East Anglia One North (EA1N) and East Anglia Two (EA2) Offshore Wind Farms

Planning Inspectorate Reference: EA1N – EN010077 & EA2 – EN010078

East Suffolk Council's Summary of Oral Case - Issue Specific Hearing 16

Issue Specific Hearing 16 (26 May 2021) – The Proposed Substations Site

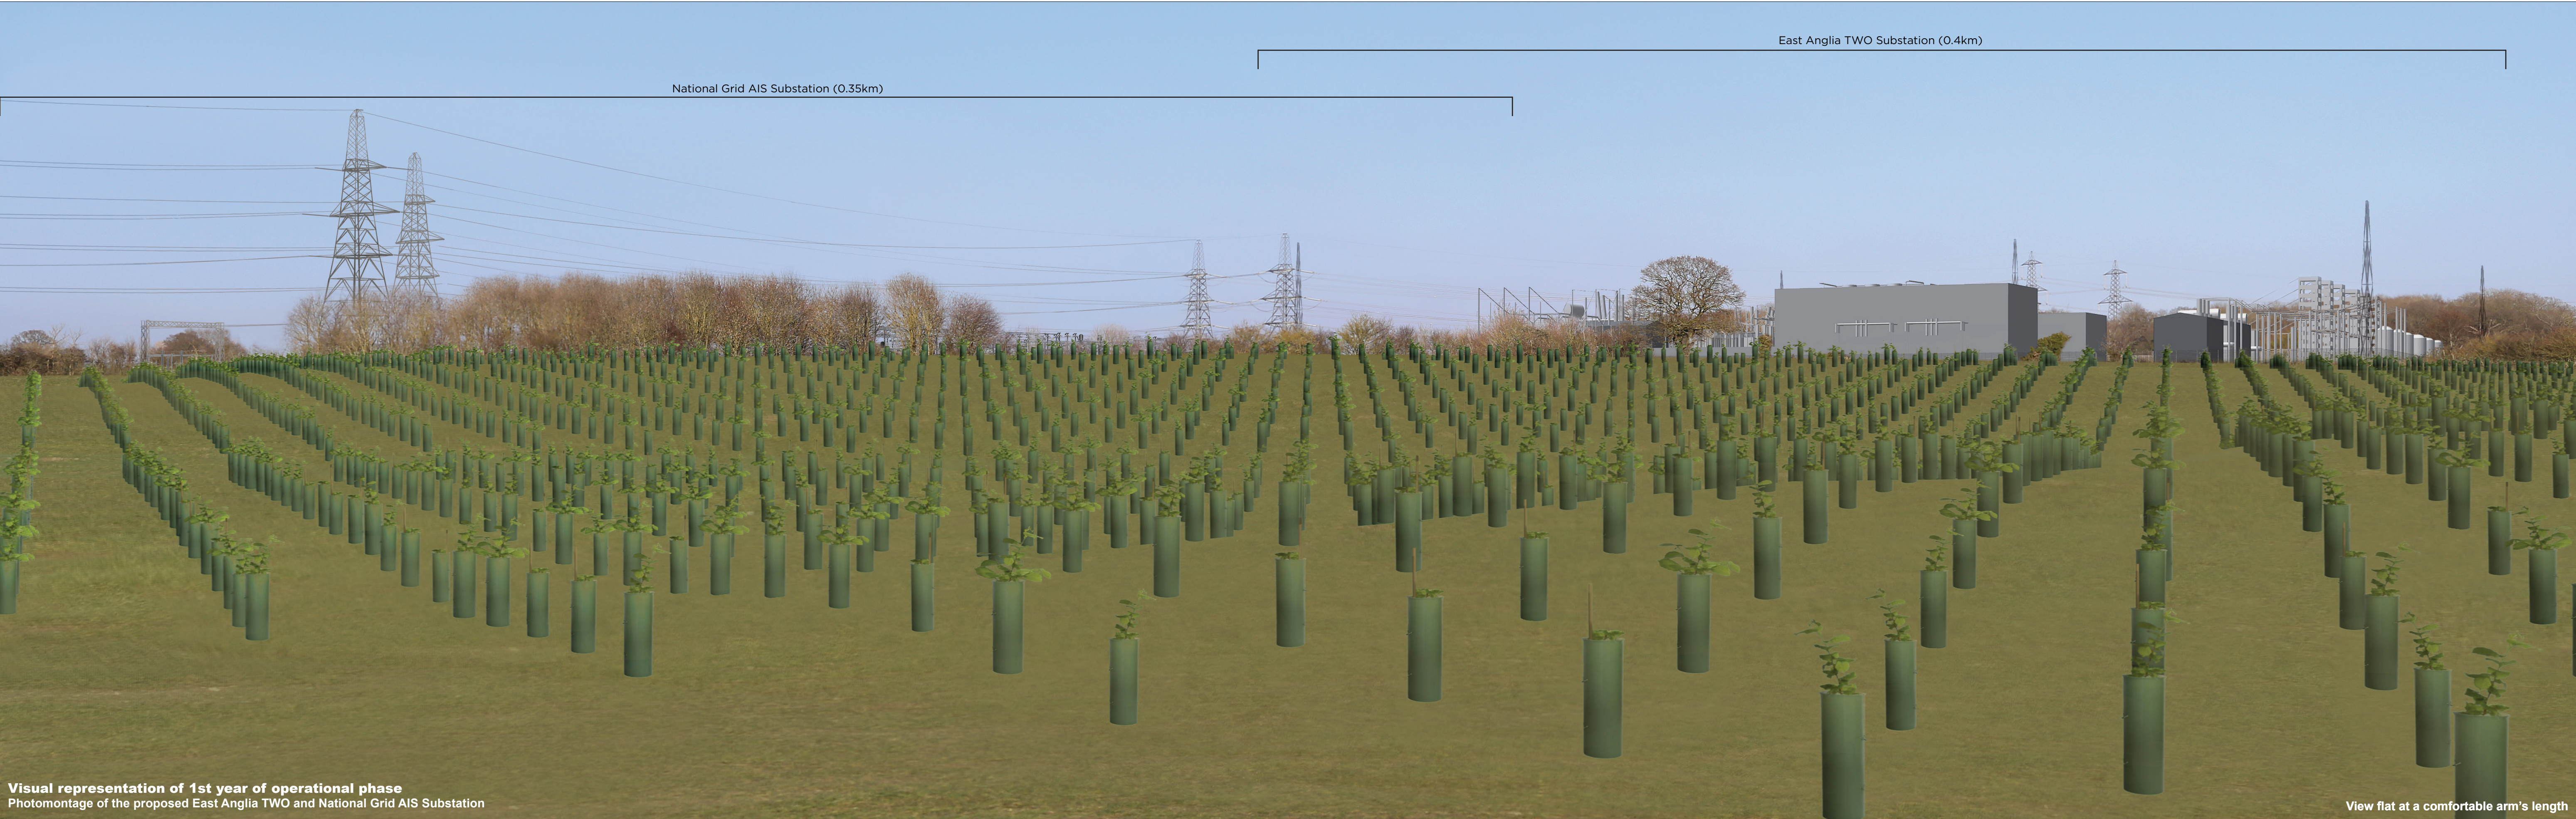
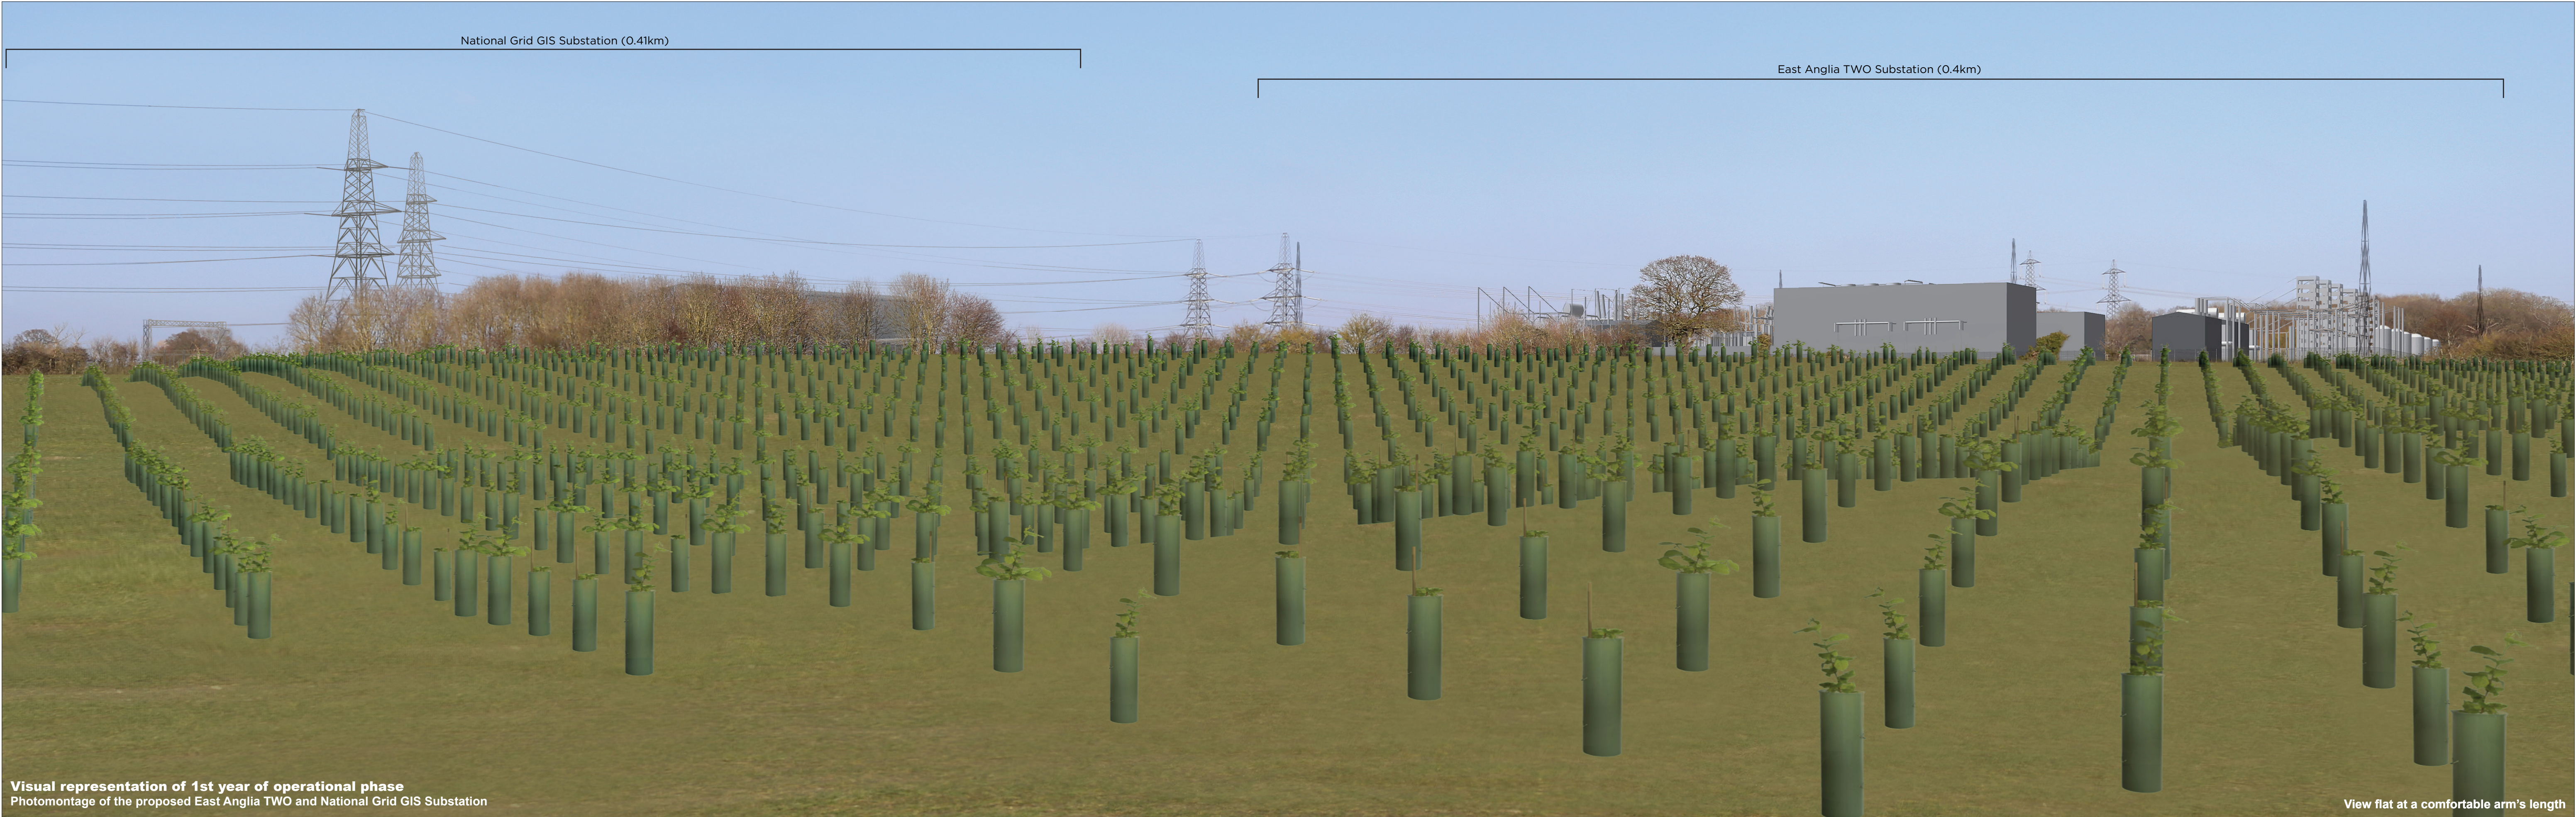
<p>this would be addressed, and the properties included within the direct engagement strategy.</p> <p><i>National Grid Substation</i></p> <p>ESC requested that the Applicants provide an assessment of the National Grid Gas Insulated Switchgear (GIS) substation which should include the consideration of alternatives to sulphur hexafluoride (SF6) (REP1-132, REP8-041). The Environmental Statements are based on the use of an Air Insulated Switchgear (AIS) substation, although the Applicants have provided visualisations to show what a GIS substation would look like. Although the visualisations are useful, it is not possible for ESC to fully compare the impacts of the two technologies and assess the degree to which one technology is beneficial over the other. The lack of a full assessment of the GIS option also limits the Examining Authority’s ability to recommend to the Secretary of State that one technology should be favoured over another and prevents the ability for only the GIS option to be consented by the DCOs.</p> <p>ESC supports the Applicants recent commitment at Deadline 10 (REP10-007) to provide an assessment of a GIS substation at Deadline 11.</p> <p>ESC has noted and welcomed the engagement the Applicants have undertaken with the supply chain in relation to the onshore project substations in order to seek reductions in the maximum parameters. ESC supports the continuation of this work through the post consent design refinement work. ESC however notes that National Grid has</p>

<p>not undertaken similar work and endeavoured to seek reductions in the parameters of their substation.</p> <p><i>Connections for Future Projects</i></p> <p>ESC has made recent representations in relation to the cumulative impacts of the current applications with future projects, most recently at Deadline 9 (REP9-040 and REP9-041). The Council however notes the Examining Authorities desire to deal with this matter through written submissions and not at this hearing.</p>	
Agenda Item 3 – Flood Risk and Drainage			
<ul style="list-style-type: none"> • Flood risk and drainage during construction • Operational flood risk and drainage <ul style="list-style-type: none"> a) Results and implications of infiltration testing b) Indicative design c) Outline Operational Drainage Management Plan submitted at D8 [REP8-064] including but not limited to: <ul style="list-style-type: none"> • Infiltration/hybrid storage volumes • Discharge to Friston watercourse • Adoption and maintenance d) Relationship with the Outline Landscape and Ecological 		<p>ESC will defer to Suffolk County Council (SCC) as the Lead Local Flood Authority (LLFA) on technical drainage and flood risk matters.</p> <p>d) The Applicants have submitted responses to the Examining Authorities’ Rule 17 letter dated 13 May 2021 in the form of the following two documents:</p> <ul style="list-style-type: none"> • Applicants’ Response to Rule 17 Questions of 13 May: Initial Infiltration Testing Preliminary Results (AS-121); and • Applicants’ Response to Rule 17 Questions of 13 May: Design and Layout of the Substations (AS-122). <p>The drainage submission provides details of the initial infiltration testing results and a commentary on how the infiltrate rates were identified. The second submission provides a series of drawings to illustrate that based on these infiltration rates, sufficient land is available within the Order Limits to deliver the Outline Mitigation Management Plan (OLMP) planting and an infiltration only SuDS</p>
